Engineers Comments Regarding Surface Water Drainage

NOTIFICATION FROM ARUN DISTRICT COUNCIL
Town & Country Planning Act 1990 (as amended)
Town and Country Planning (Development Management Procedure) (England) Order 2015
Planning Permission
APPLICATION BR/242/18/PL

Registered: 30th August
2018
Site Address: DD Motors Bersted Street Bognor Regis PO22 9QF
Grid Reference: 493342 100134

Description of Works: Single storey side extension.

Title
PROPOSED BLOCK PLAN PLUS EXISTING
AND PROPOSED FLAT ROOF HIGHLIGHTED

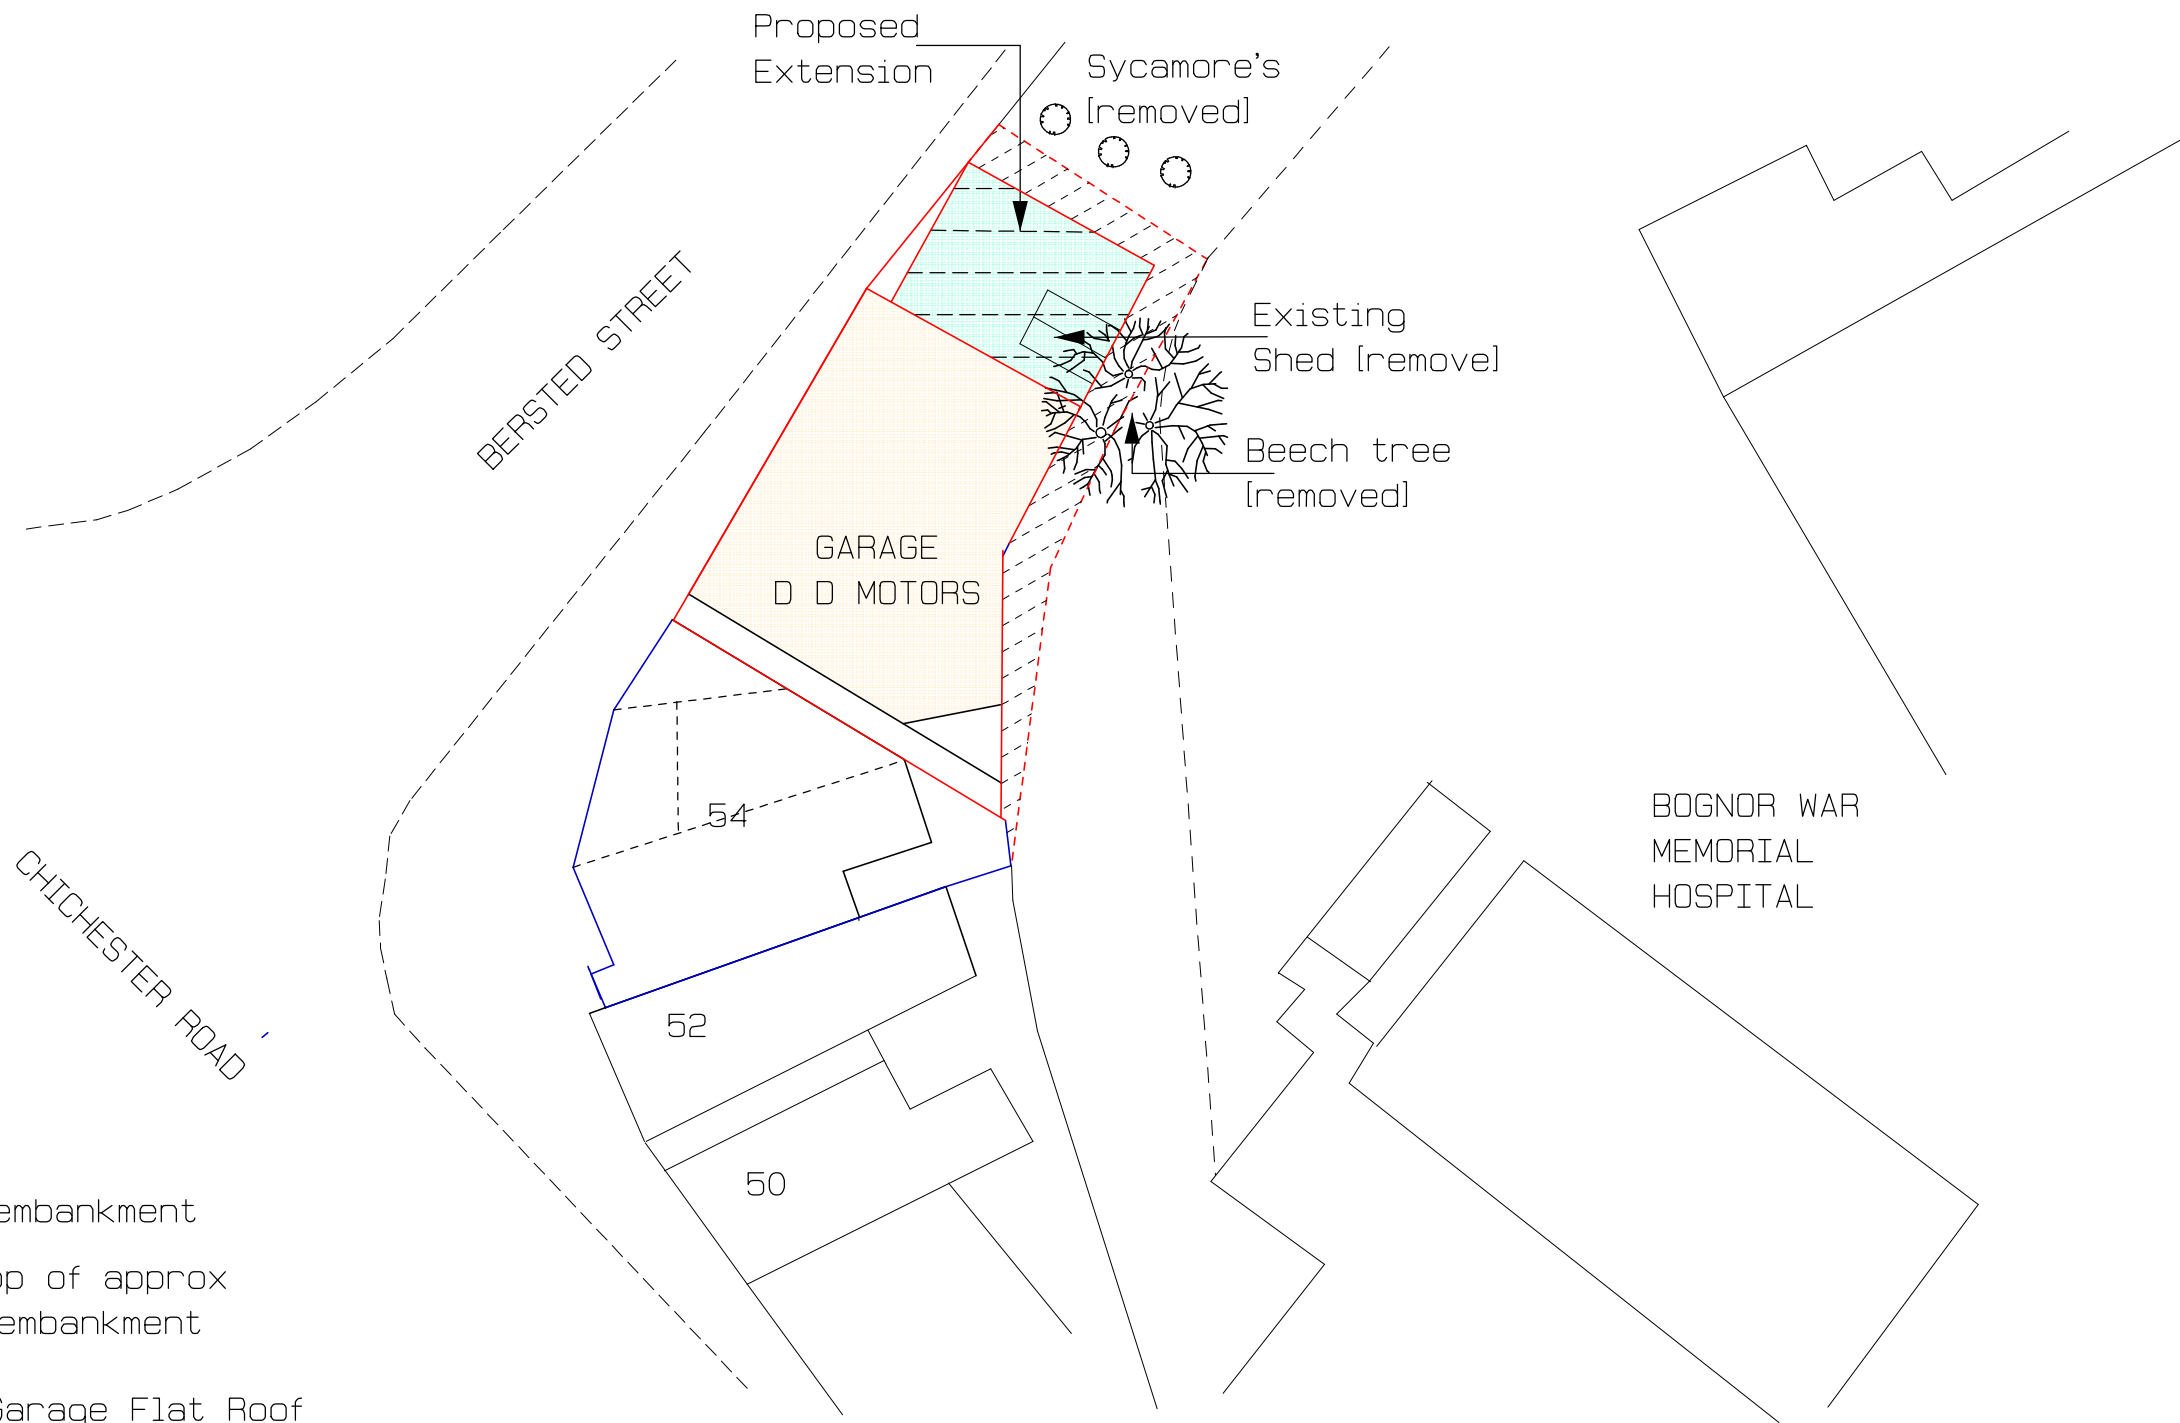
The application form states that the surface water is to be disposed of via soakaway. It is unclear from the location plans where there will be room to locate a soakaway that is 5m from buildings. It may be necessary for the surface water to connect into the surface water sewer, the necessary approvals from Southern Water will be required for this.

All surface water drainage should be designed and constructed to meet building regulations.
